Address: Talisker, 8 Highcroft Holmfirth HD9 3HE

Application number: 2022/92799	
What is the application for?:	Erection of extensions, conversion of existing attached barn to living accommoda
Address of the site or building:	17, Town Gate, Upperthong, Holmfirth, HD9 3UX
Postcode:	HD9 3UX

Type of comment: An objection	
Do you wish your comments to be published on the website anonymously?	No

Drawing
Planning Application
Proposed elevations and sections

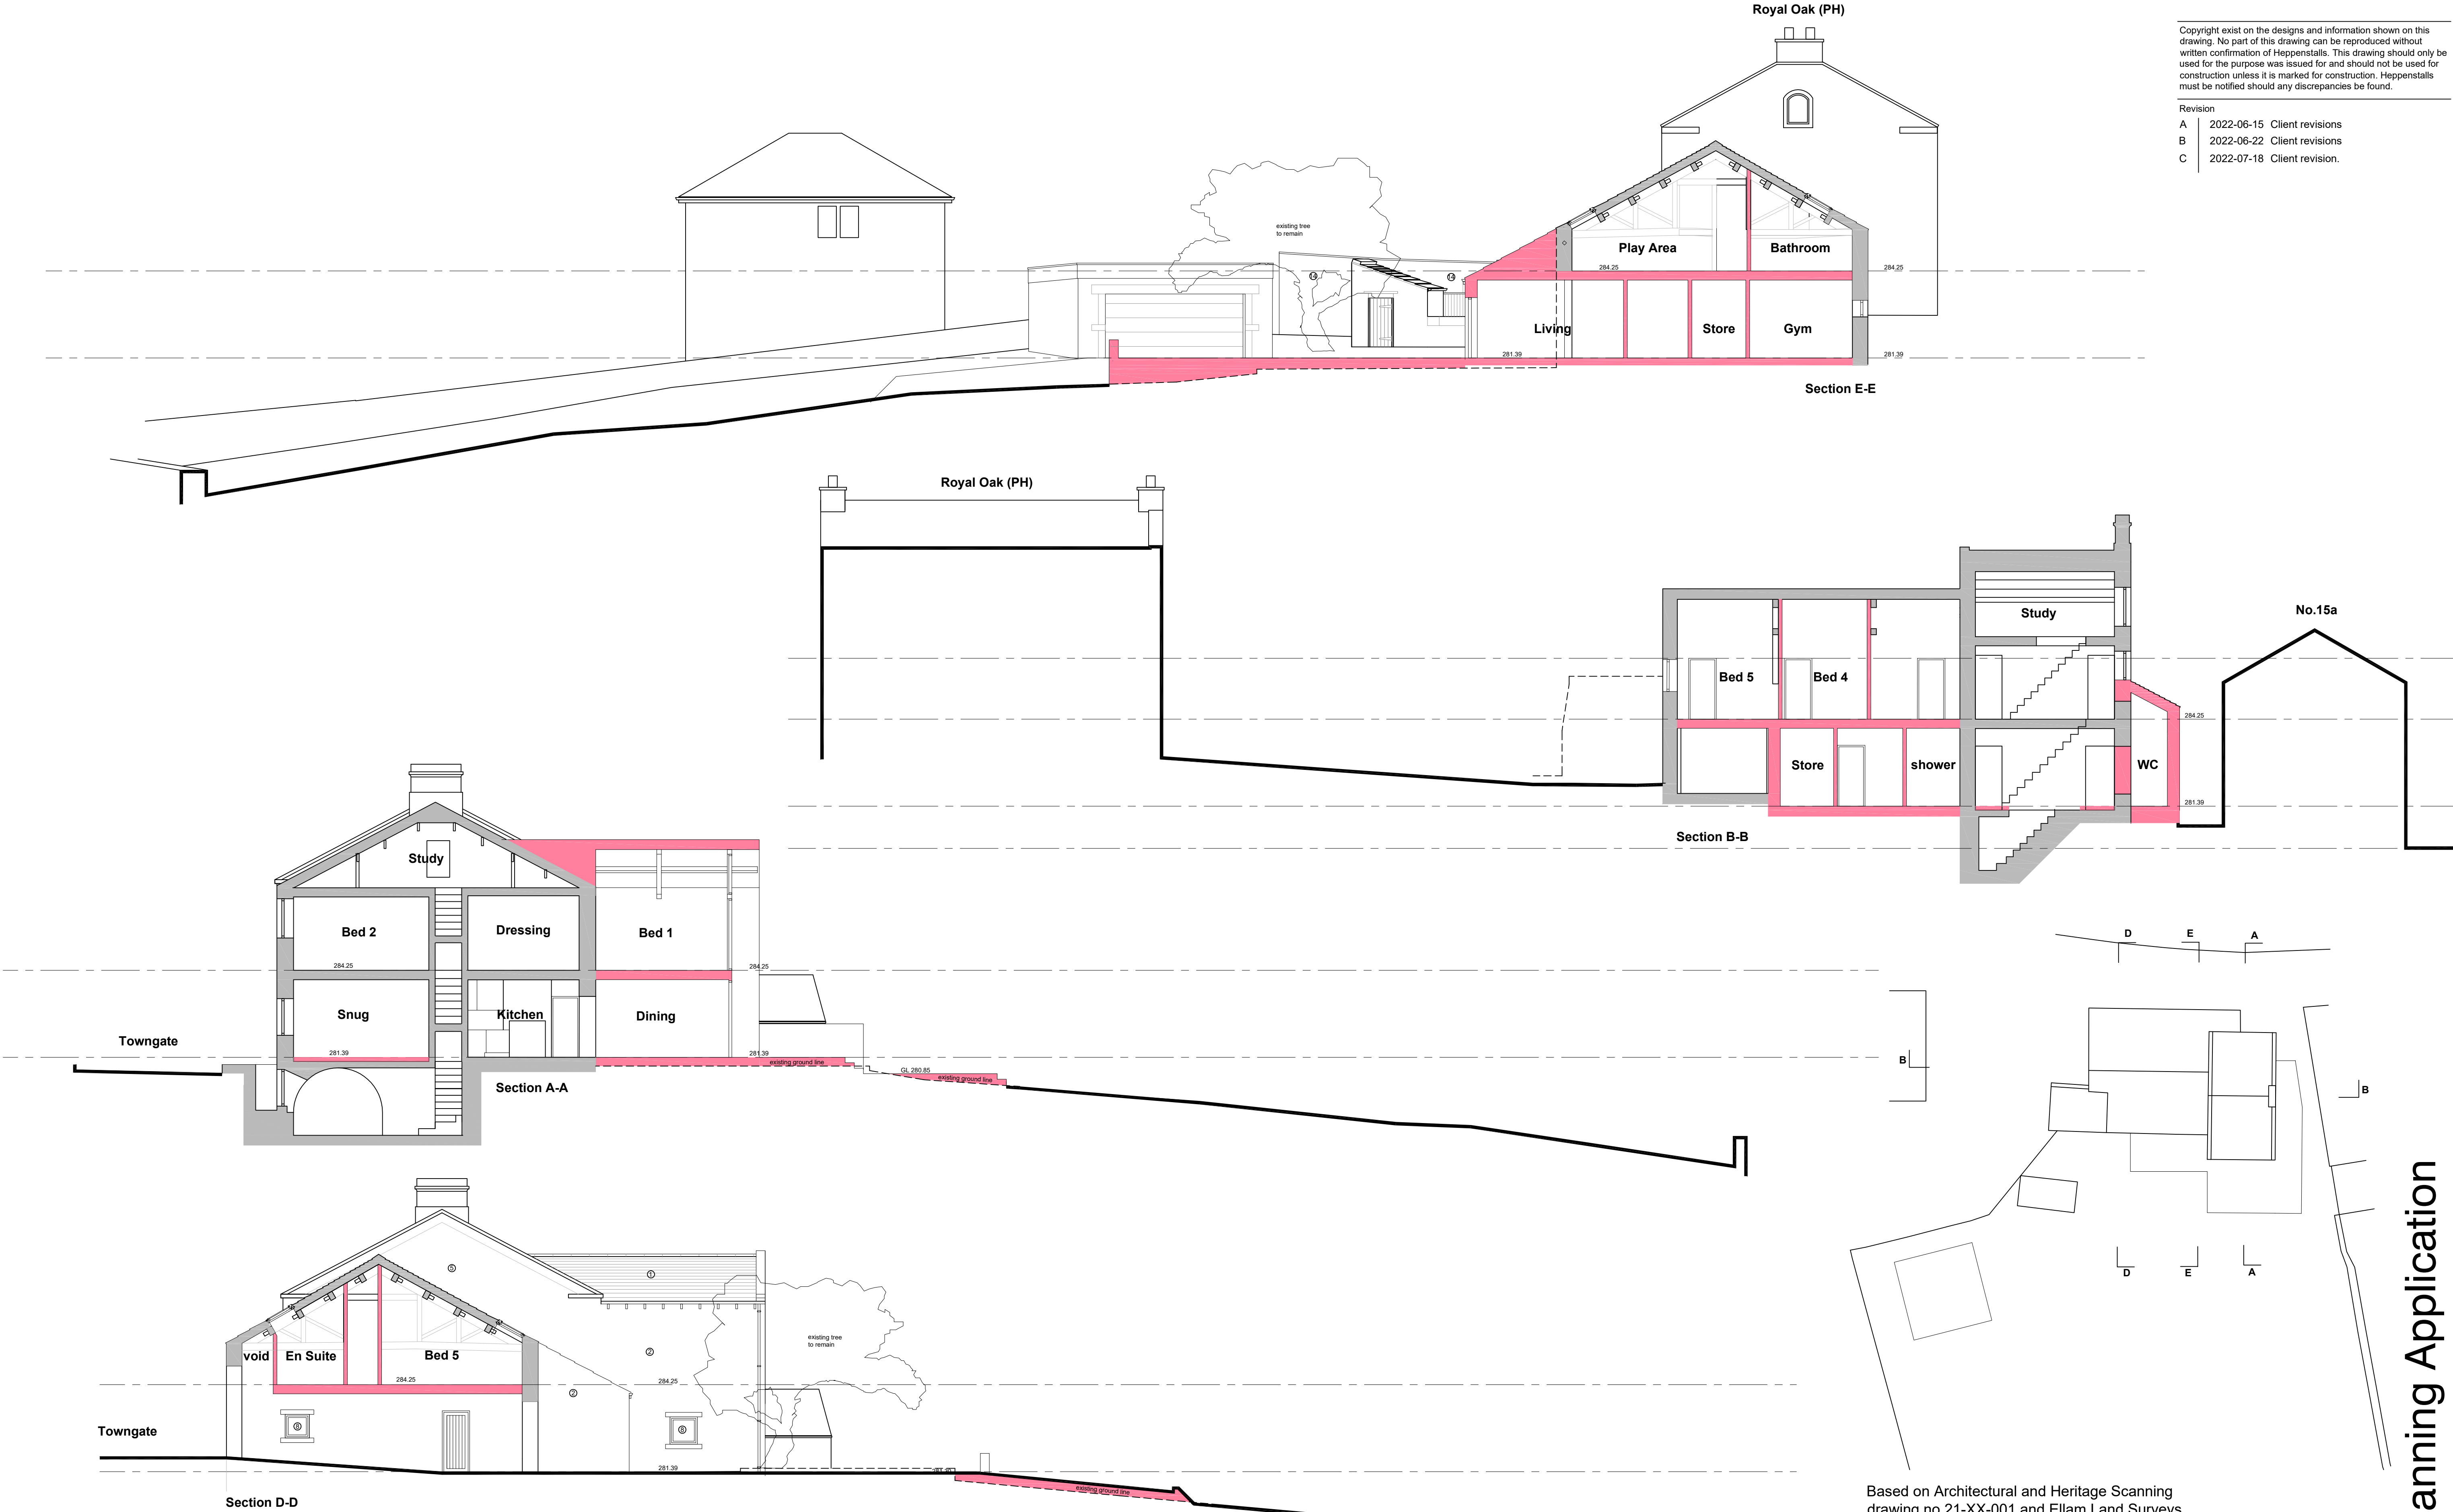
Raising the west boundary wall, will inevitably impact on the visual appearance of Town Gate. The openness at the rear of the Public House setting allows lots of natural light into Town Gate. The Royal Oak pub is the "heart of the village centre". Whilst it is not possible to protect a view on a point of law, the subject wall would greatly impact on the pub setting and openness of the public outdoor area, which many local people and tourists enjoy. This will likely have a negative impact to the Royal Oak trade and therefore to the village itself.

Full details of the planned wall have not been submitted.
